This consultation from Environmental Health refers to BE/102/14/A.(not BE/103/14/A)

From: Anna Appleton
Sent: 08 October 2014 10:40
To: Planning.Responses
Subject: BE/103/14/A - Marks and Spencer, Arun Retail Park

08 SERVICE YARD
422 NTS PROPOSED PLANT ELEVATION DETAILS

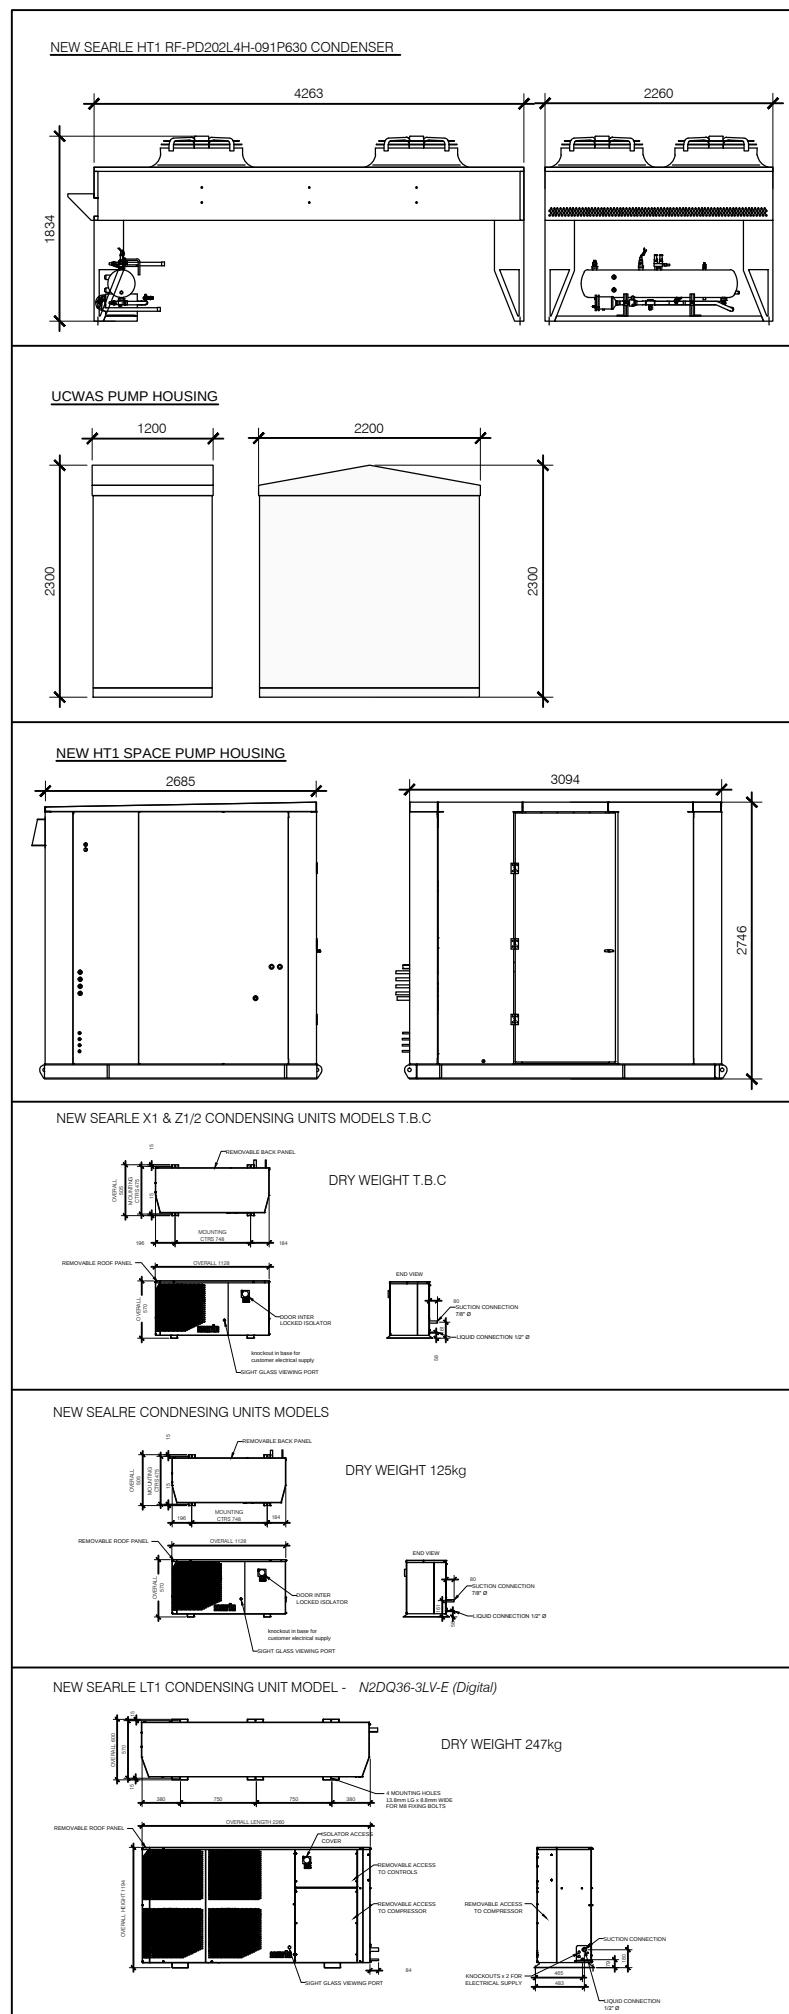
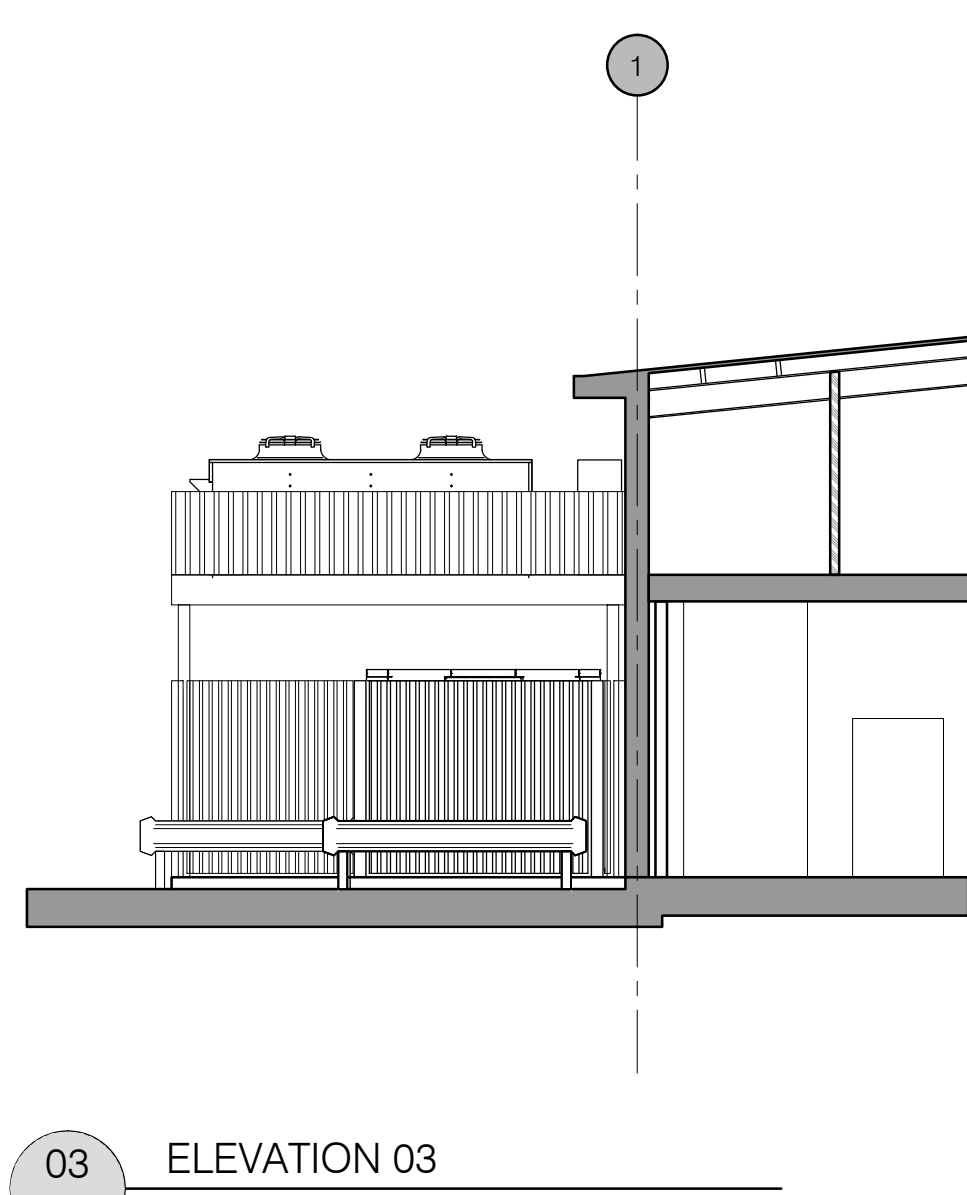
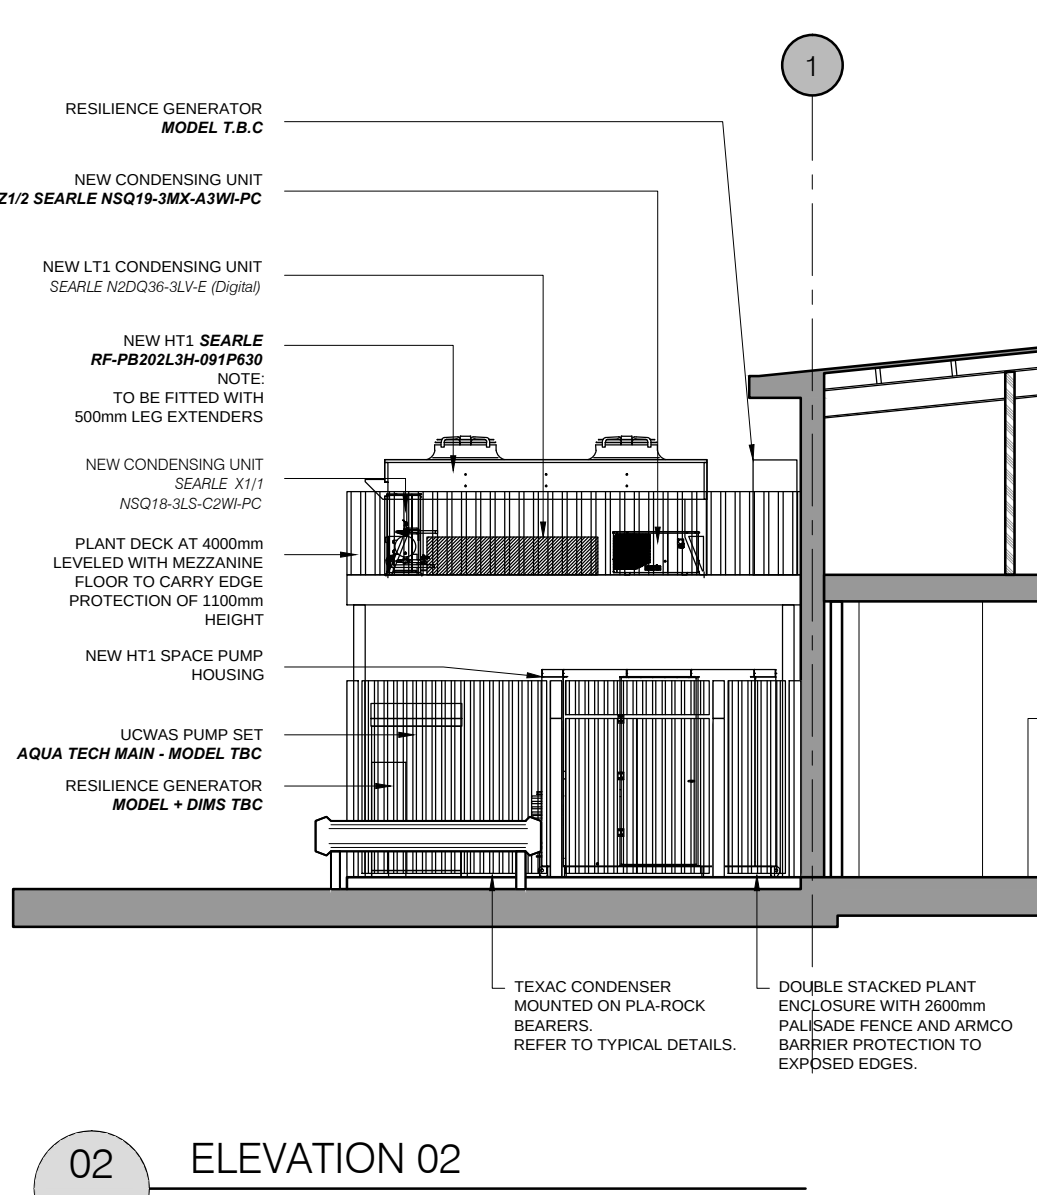
Paragraph 3.1.6 details appropriate noise levels for plant associated with the site based on background measurements taken and BS4142. In order to avoid possible noise disturbance to neighbours the levels set out in this paragraph if the acoustic report should be adhered to when plant and equipment is operating.
